KITITAS COUNTY

MEMORANDUM

TO: Community Development Services
FROM: Public Works Planning Review Team
DATE: March 24, 2021
SUBJECT: BL-21-00004 Ayres

BOUNDARY LINE ADJUSTMENT BL-21-00004

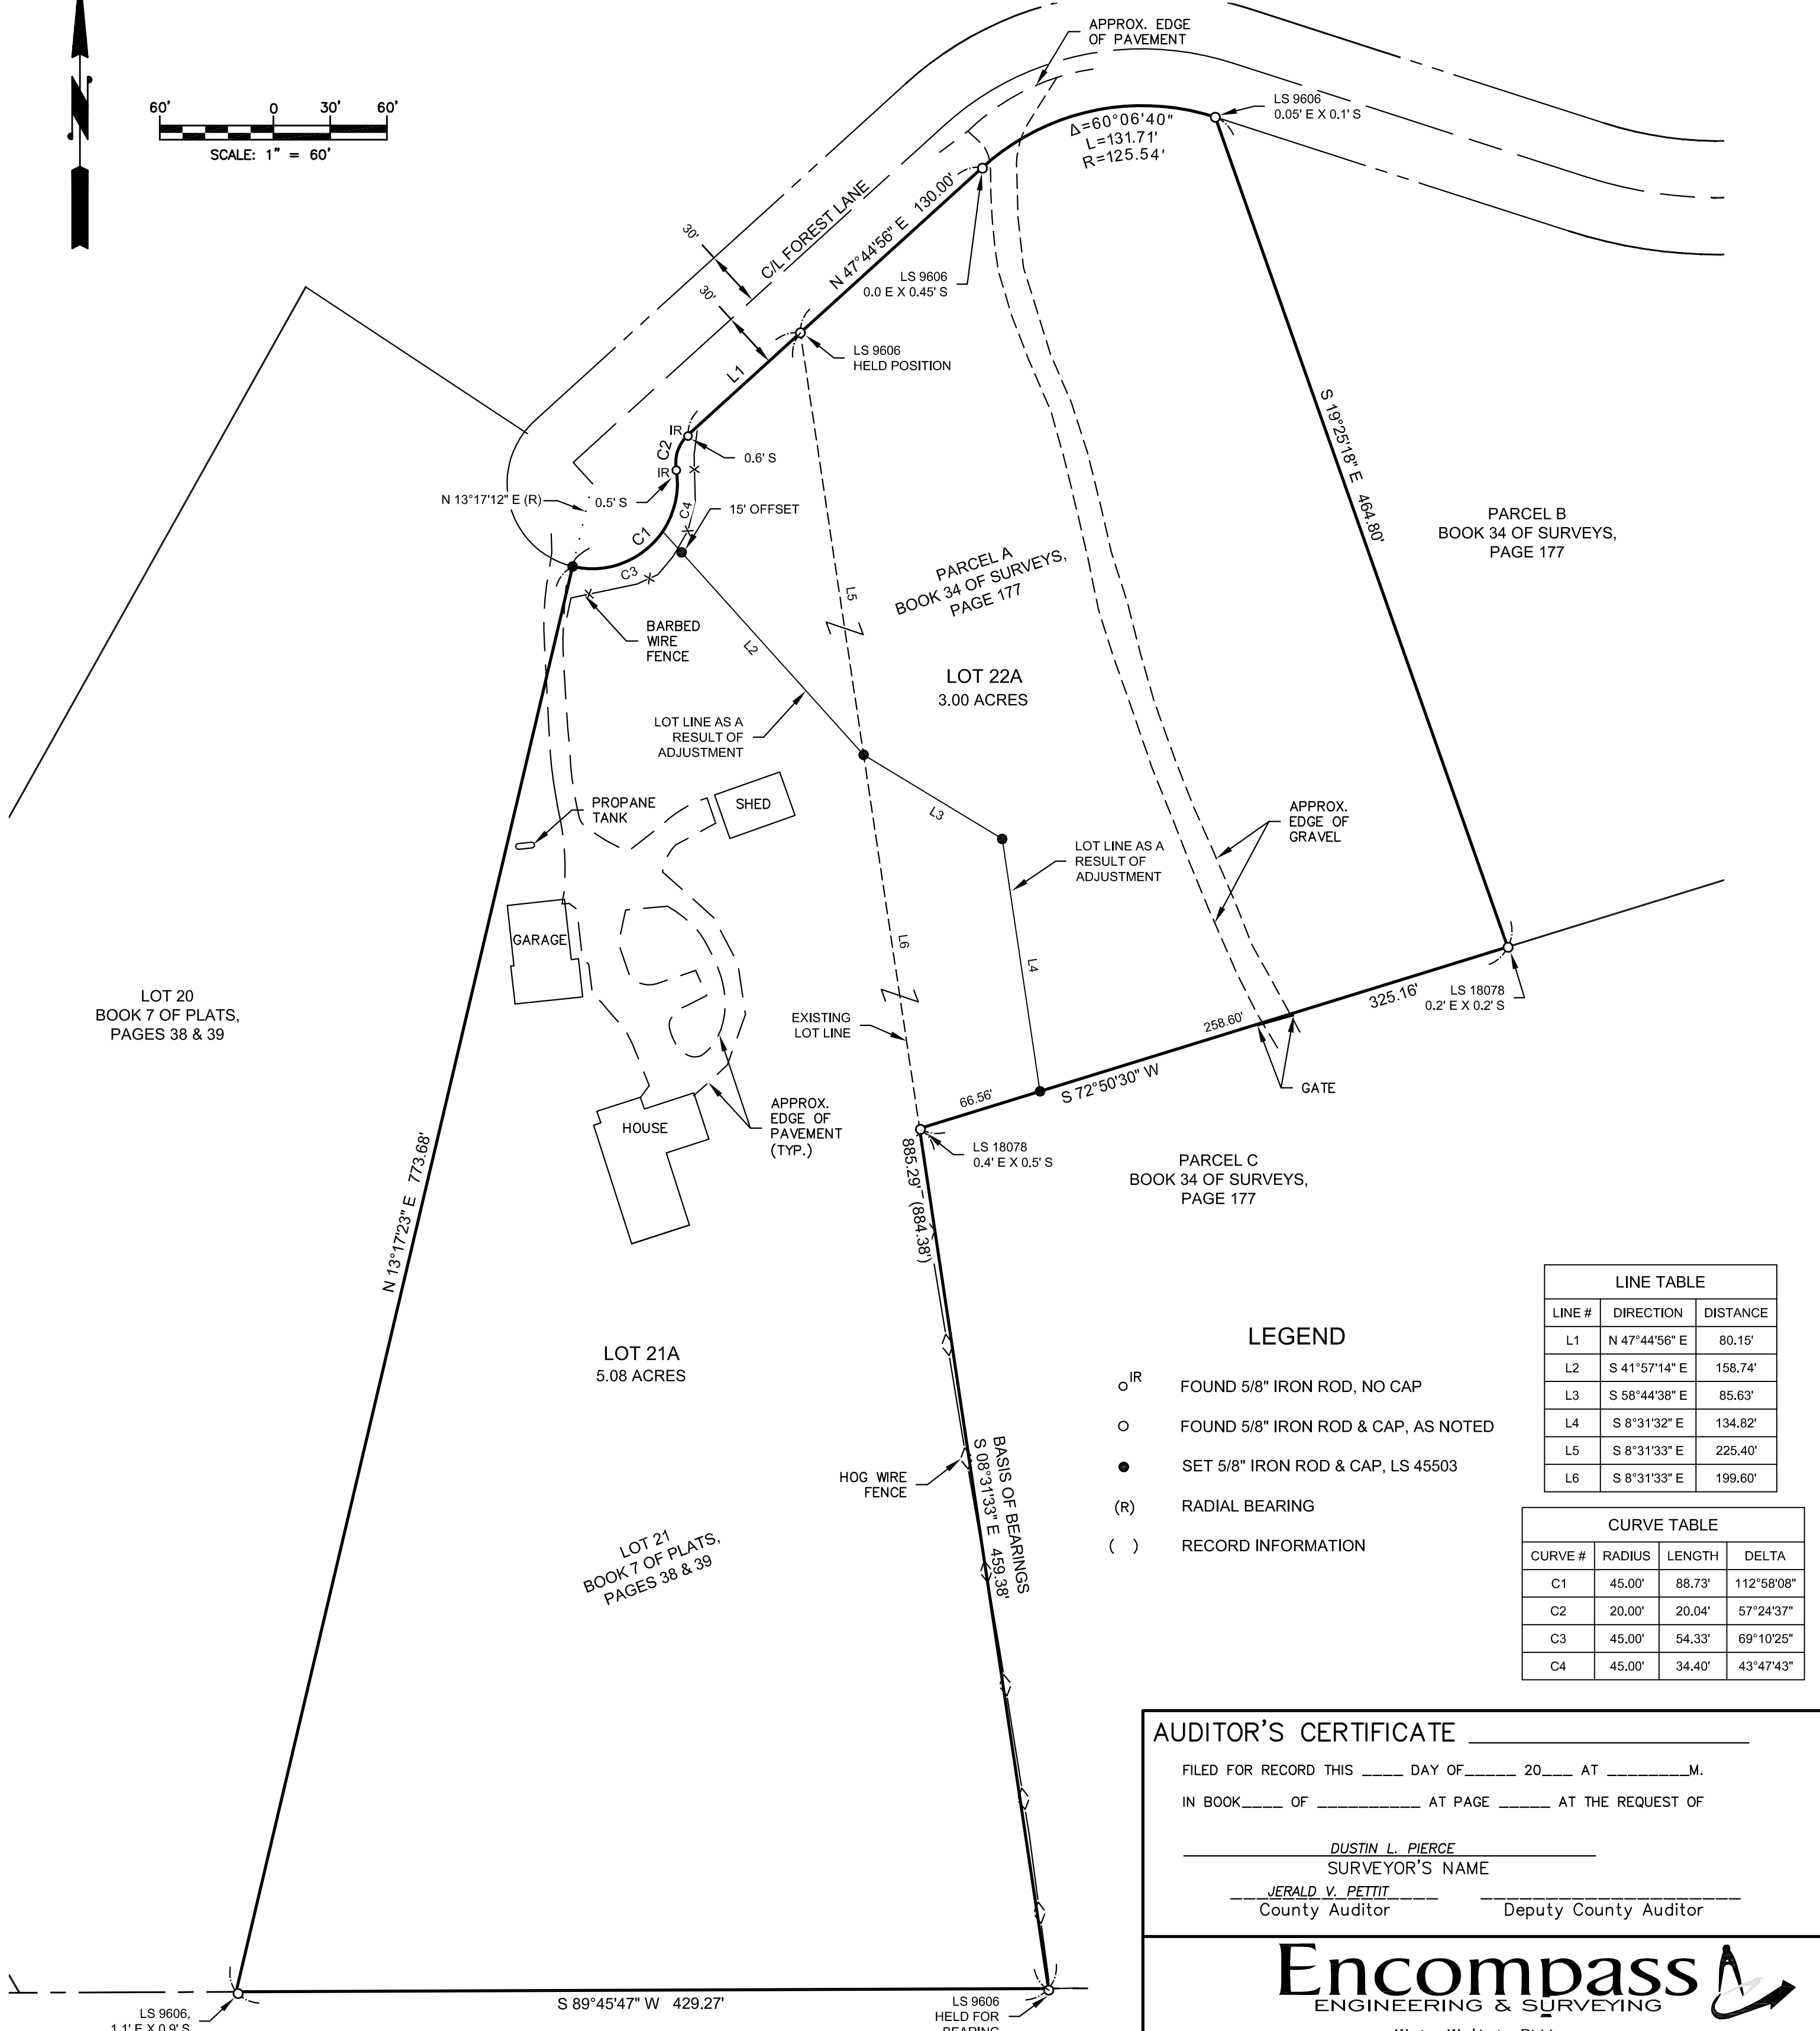
As the provided plat is more of a site plan than a record of survey, comments will be reserved until final.
